**M1 Pacific Motorway extension to Raymond Terrace (SSI 7319)
Advice on the Environmental Impact Statement (EIS)**

Thank you for the request for advice from Public Authority Consultation (PAE-24749572), requesting the review by the NSW Environment Protection Authority (EPA) of the Environmental Impact Statement (EIS) for the proposed M1 Pacific Motorway extension to Raymond Terrace (Application SSI-7319).

ATTACHMENT A: EPA COMMENT ON EIS FOR M1 PACIFIC MOTORWAY EXTENSION TO RAYMOND TERRACE (SSI 7319)

Location: L02 - 54 Weakleys Drive, Beresfield

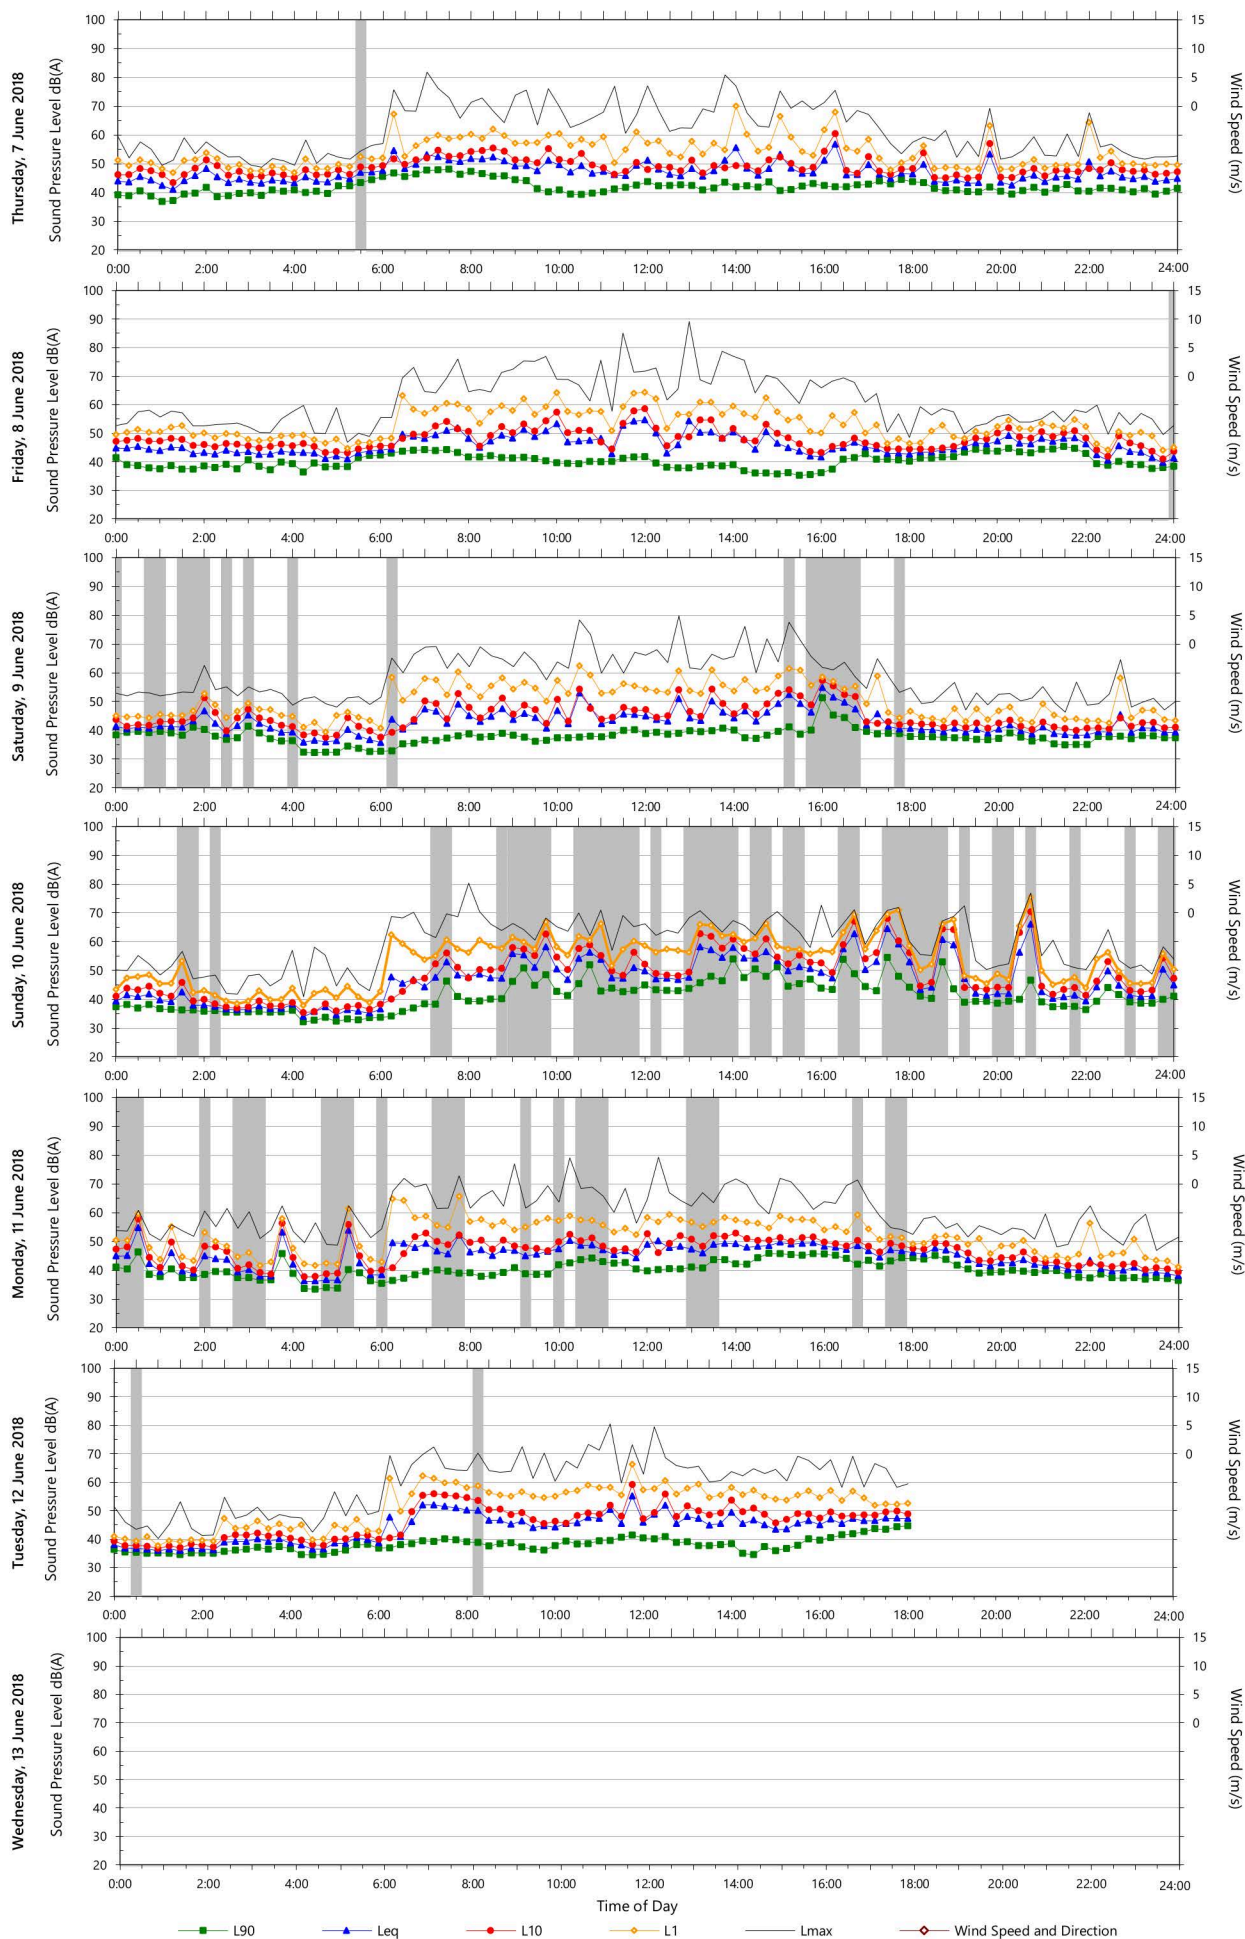
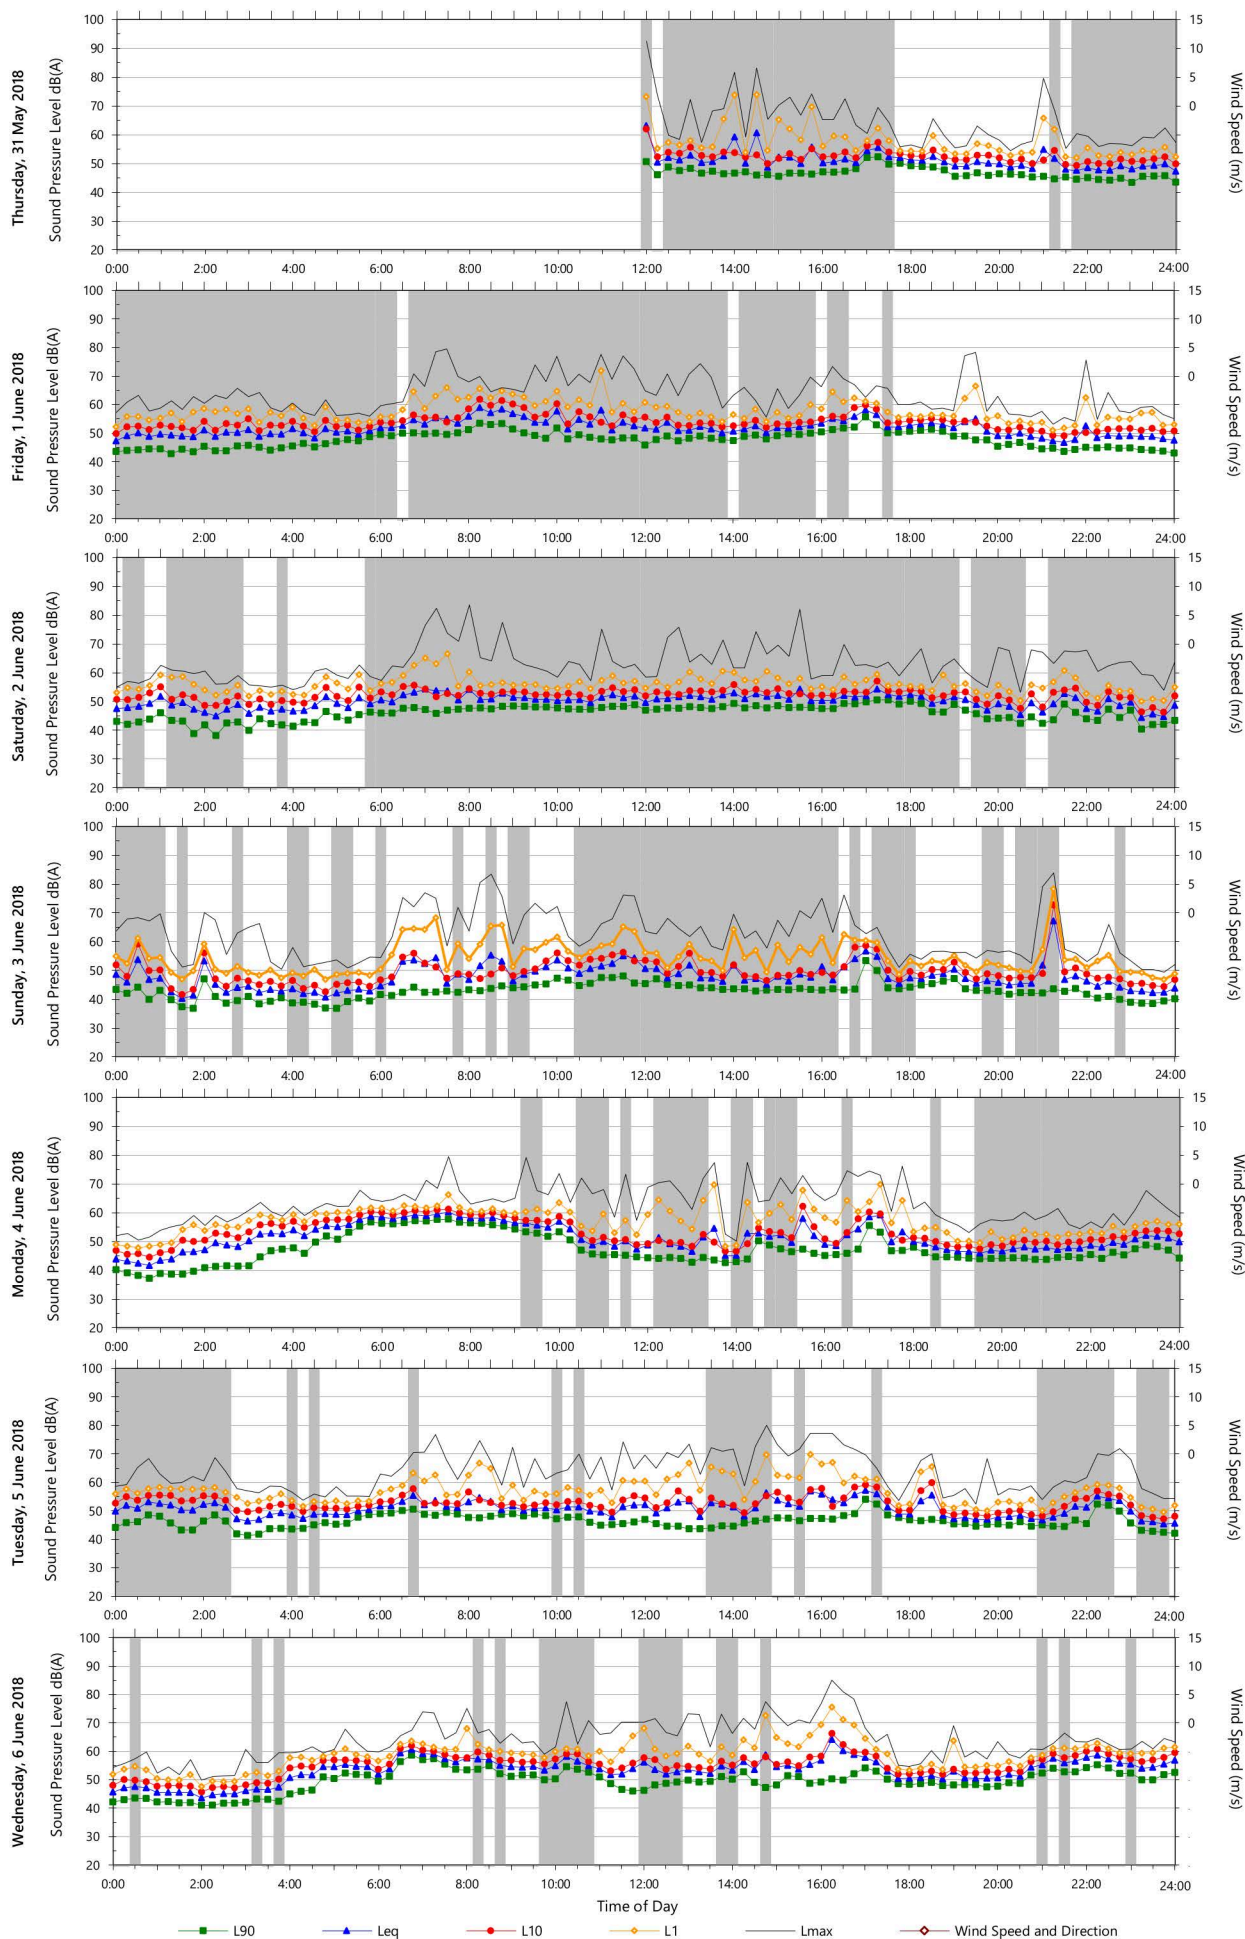
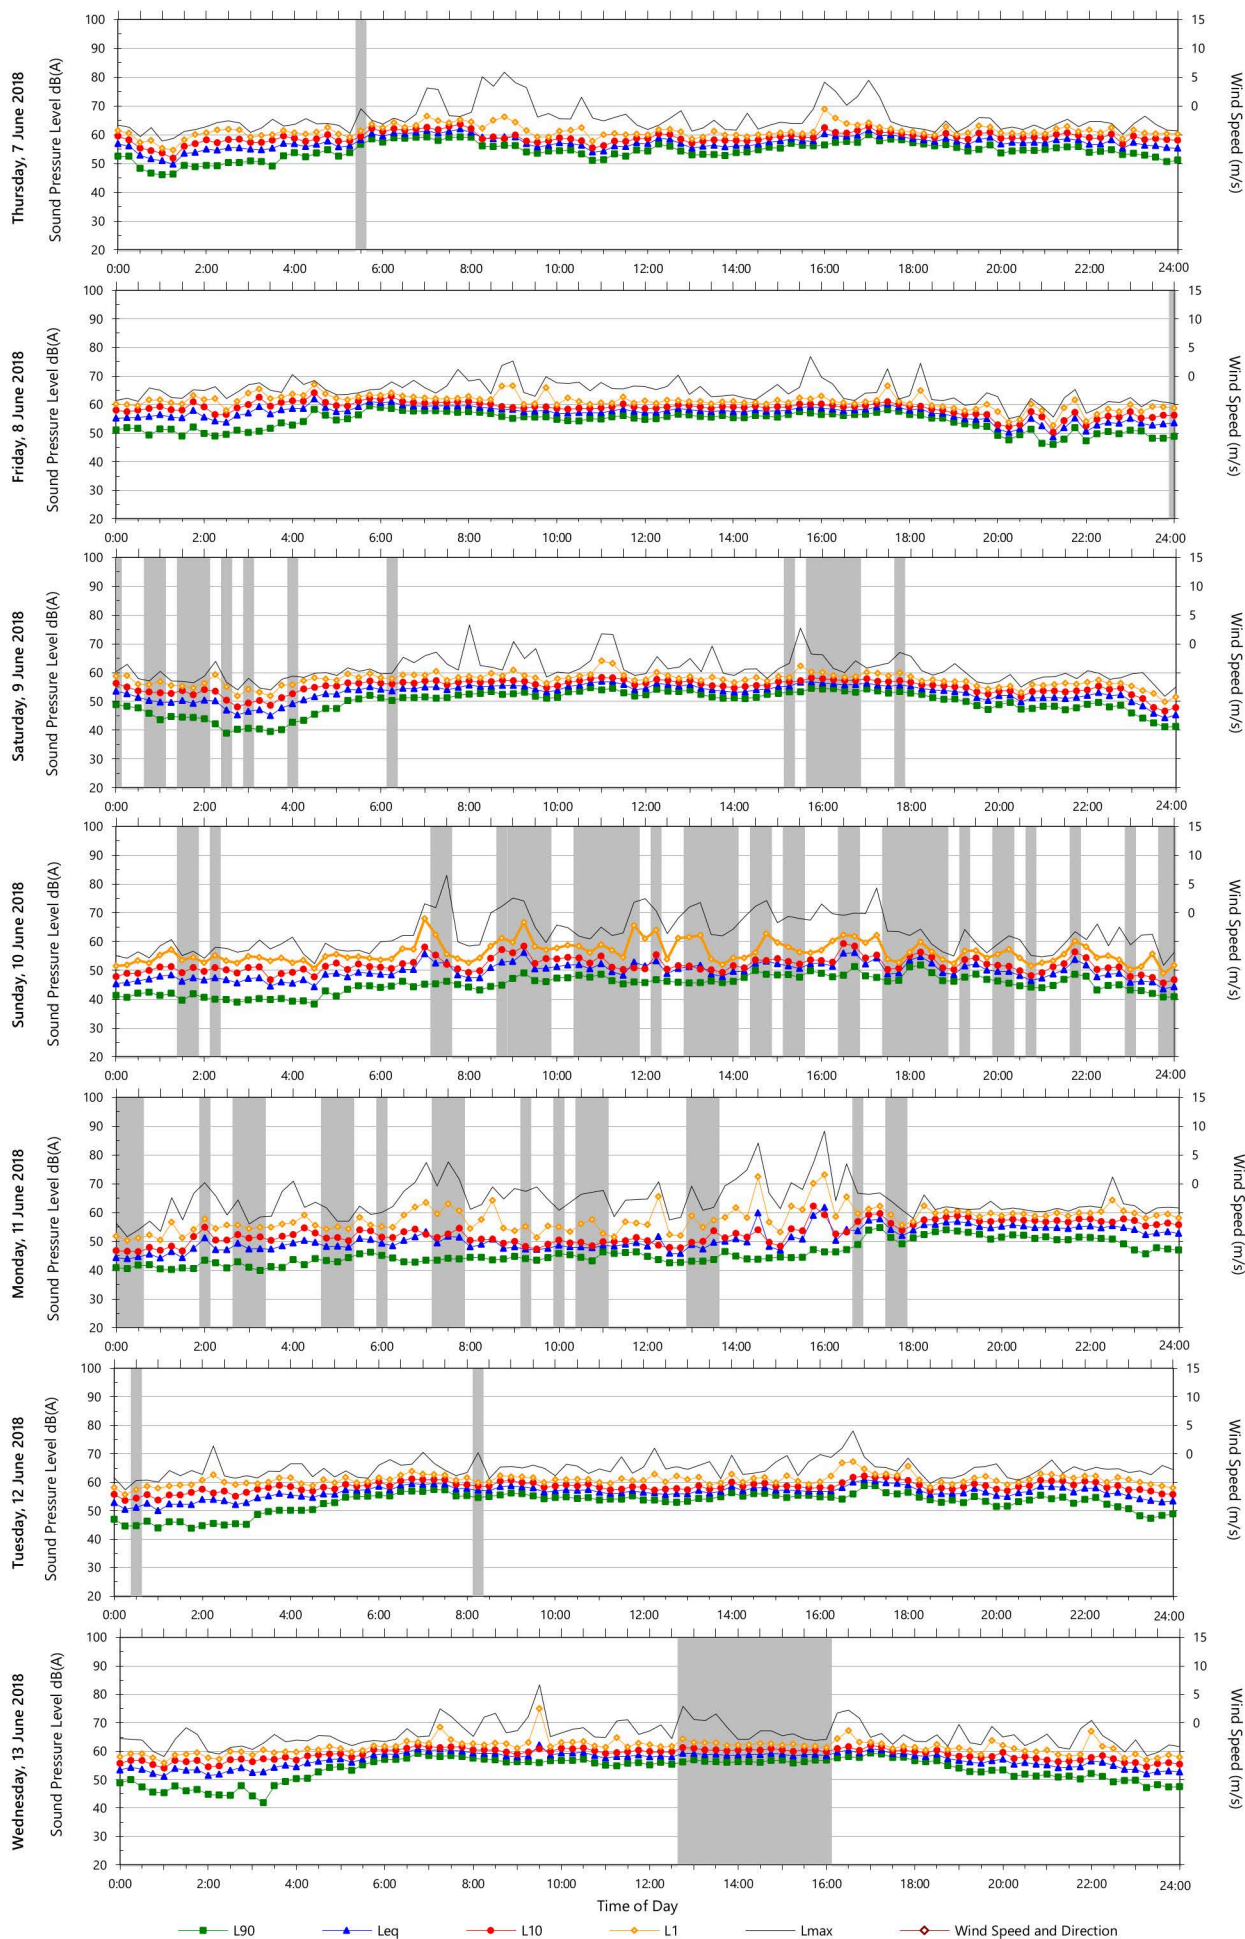
A review of the noise monitoring graphs in NIA Appendix B.2 indicates that further justification for the adequacy of noise monitoring presented or additional information is required.

A significant amount of data appears to have been excluded due to either inclement weather or extraneous noise. The EPA is concerned that the extent of data excluded means that it may not be representative of long term background noise levels, and therefore its suitability to be used to establish reliable noise management levels could be called into question.

Locations L01 to L014 (inclusive) appear to have no more than 5 and in some cases less than 3 valid periods out of the total monitoring duration. Locations L15 to L20 appear to be less affected, however there it is still not clear if sufficient valid data has been presented.

Fact Sheets A and B in the Noise Policy for Industry (NPfI) set out the EPA's requirements for establishing background noise levels. Due to the amount of data excluded, it is currently not clear if these requirements have been satisfied nor if sufficient valid data has been presented in order to establish representative background noise levels.

Noise monitoring was also conducted in 2016 for the purposes of measuring road traffic noise. Due to the amount of data excluded at Locations L13 to L20, further justification is needed that the remaining data, after invalid samples were excluded, provides sufficient amount of data to enable a representative calculation of the traffic noise descriptors.

The proponent reviews the noise monitoring data in the NIA in the context of the monitoring requirements set out in the NPfI and for each location and either:

- Provide a justification and demonstrate that the requirements of the NPfl have been fulfilled; or
- Provide additional data that fulfills the monitoring requirements in the NPfl.

The EPA also recommends that the proponent either:

- Provides justification and demonstrate that the data presented for road traffic noise descriptors is sufficient to be representative; or
- Provides additional valid data.
